Ref: FG/210/18/PL – Case Officer Mr Z Denton

No. 10 The Poplars, Ferring

Site Block Plan

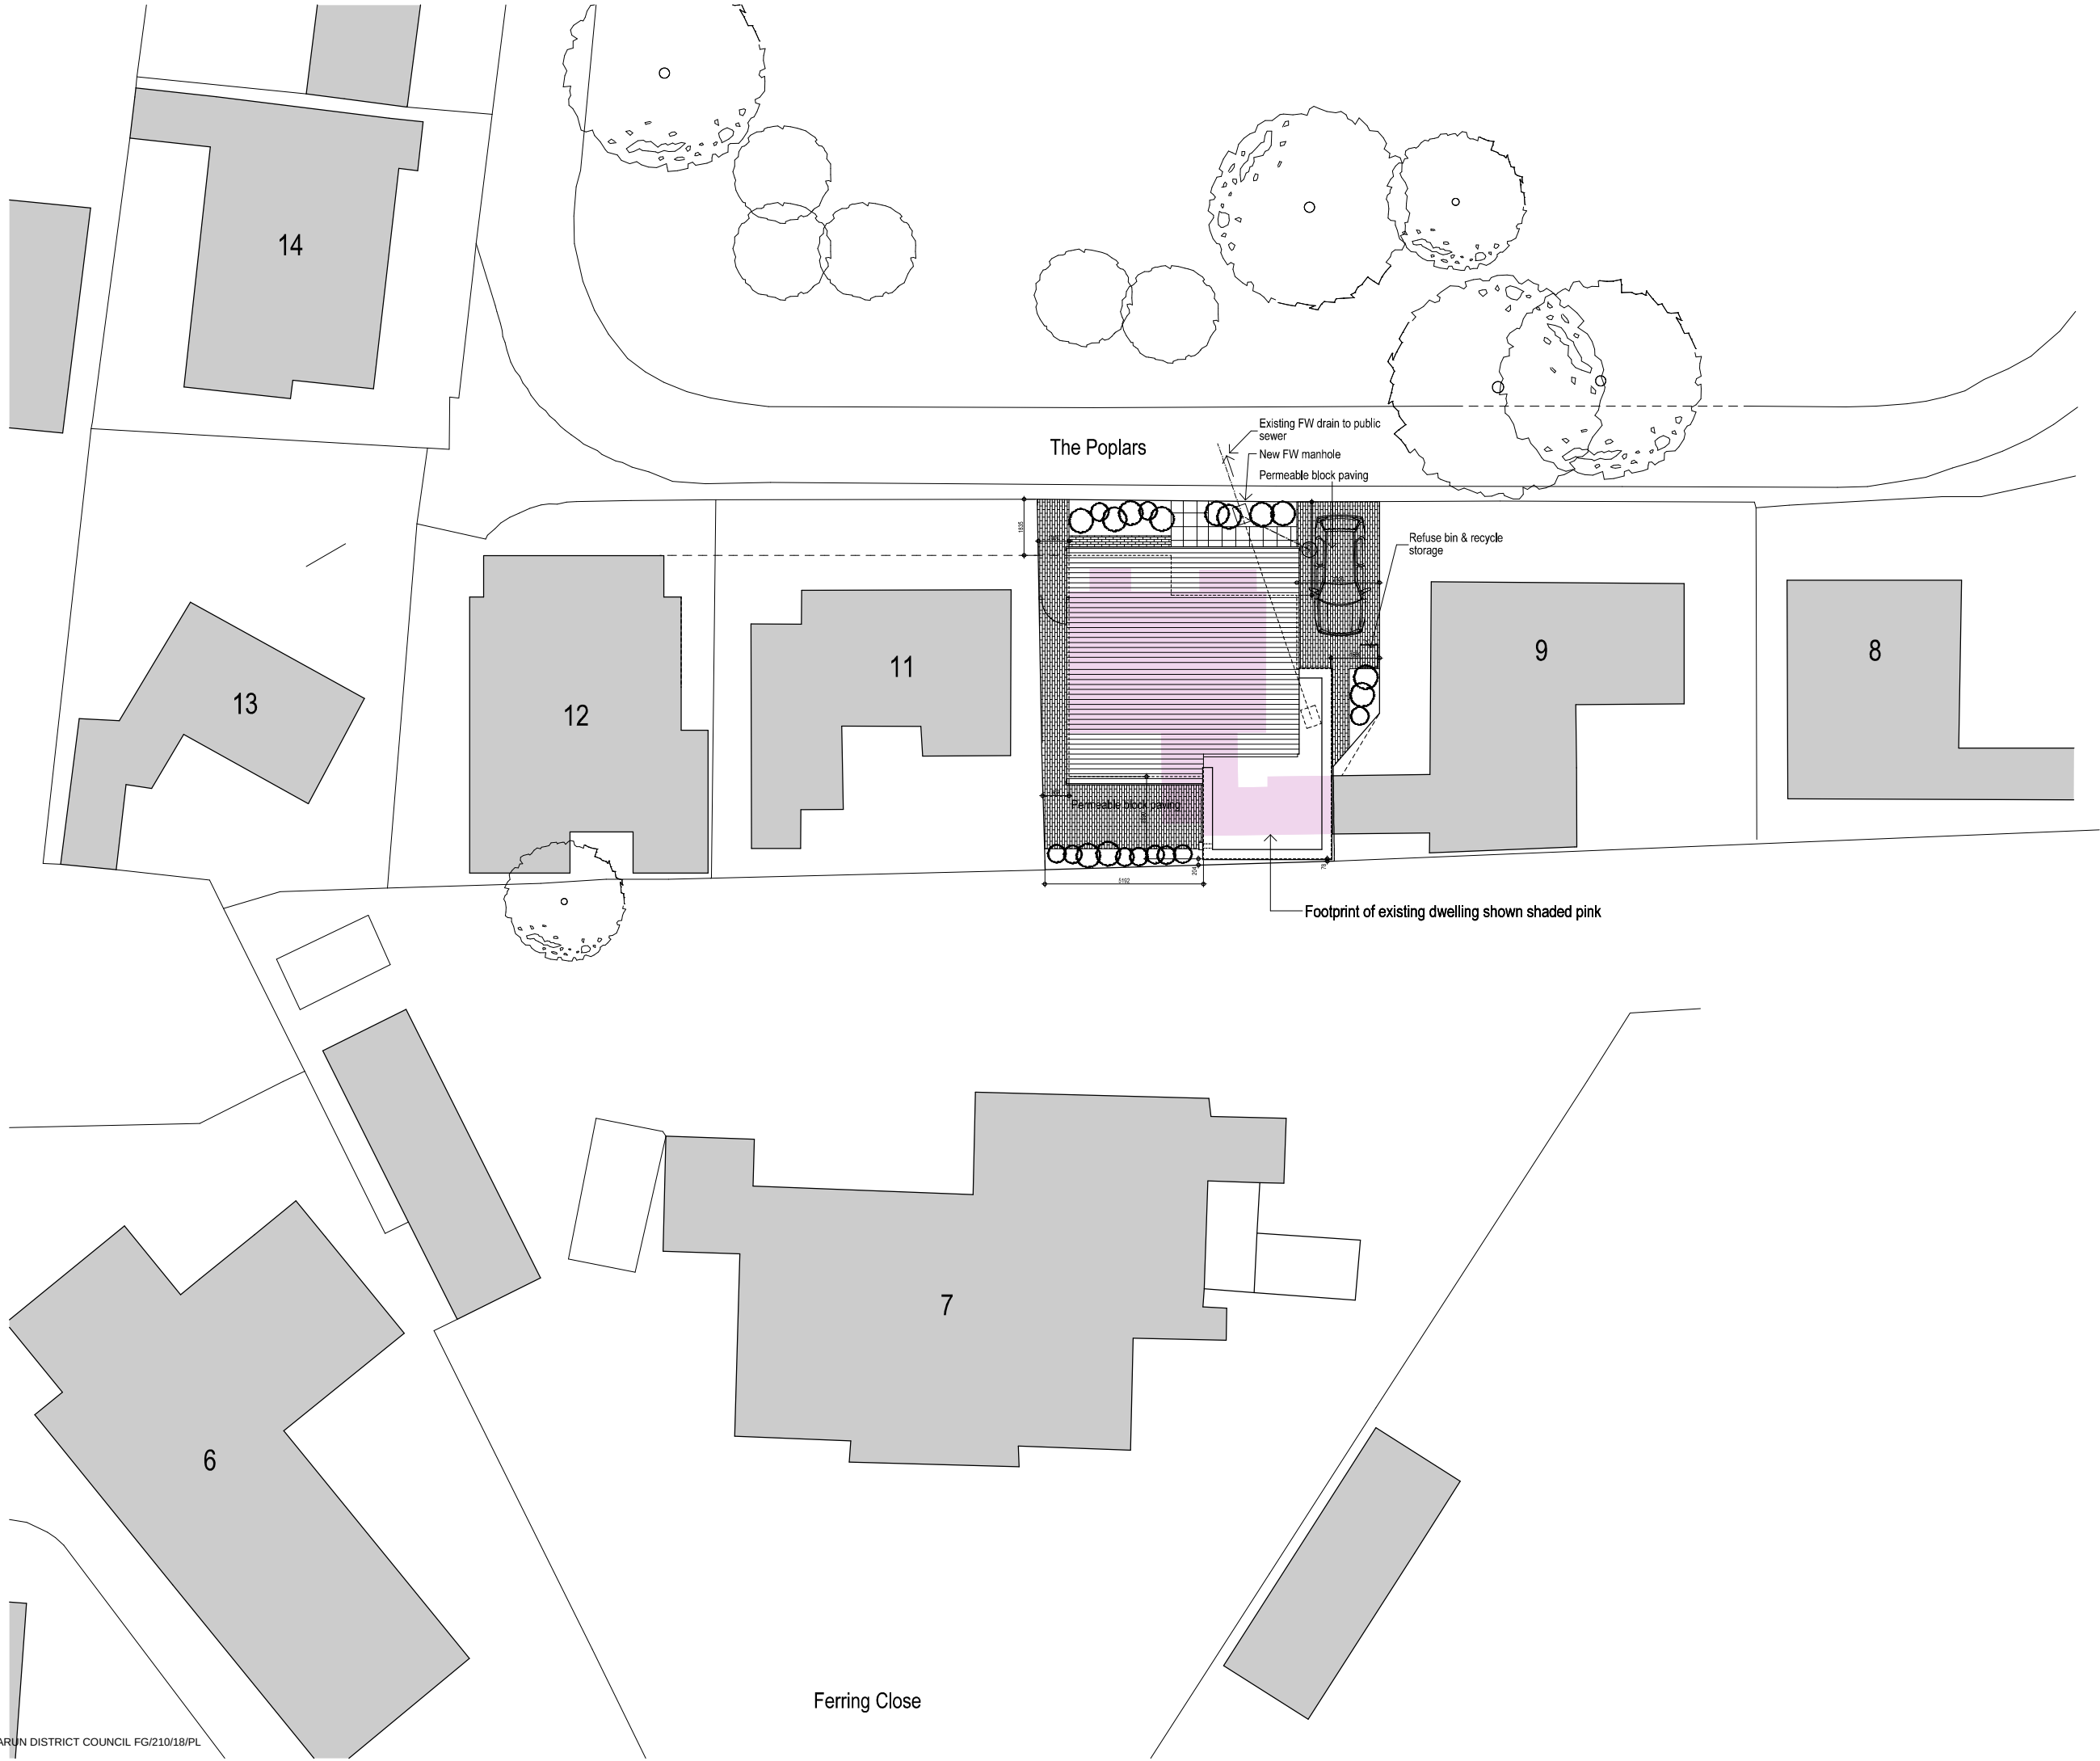
I note that the plans for the above do not show any foul or rainwater drainage. I believe that the foul drainage from No. 9 runs at the rear of No. 10 and will therefore pass under the new proposed building. As you will appreciate the drain is very old, may possibly leak, and may not be of a material that may be suitable for building over. I am not sure whether this comes under planning or some other body and hope you will pass this potential problem to the correct department to deal with.
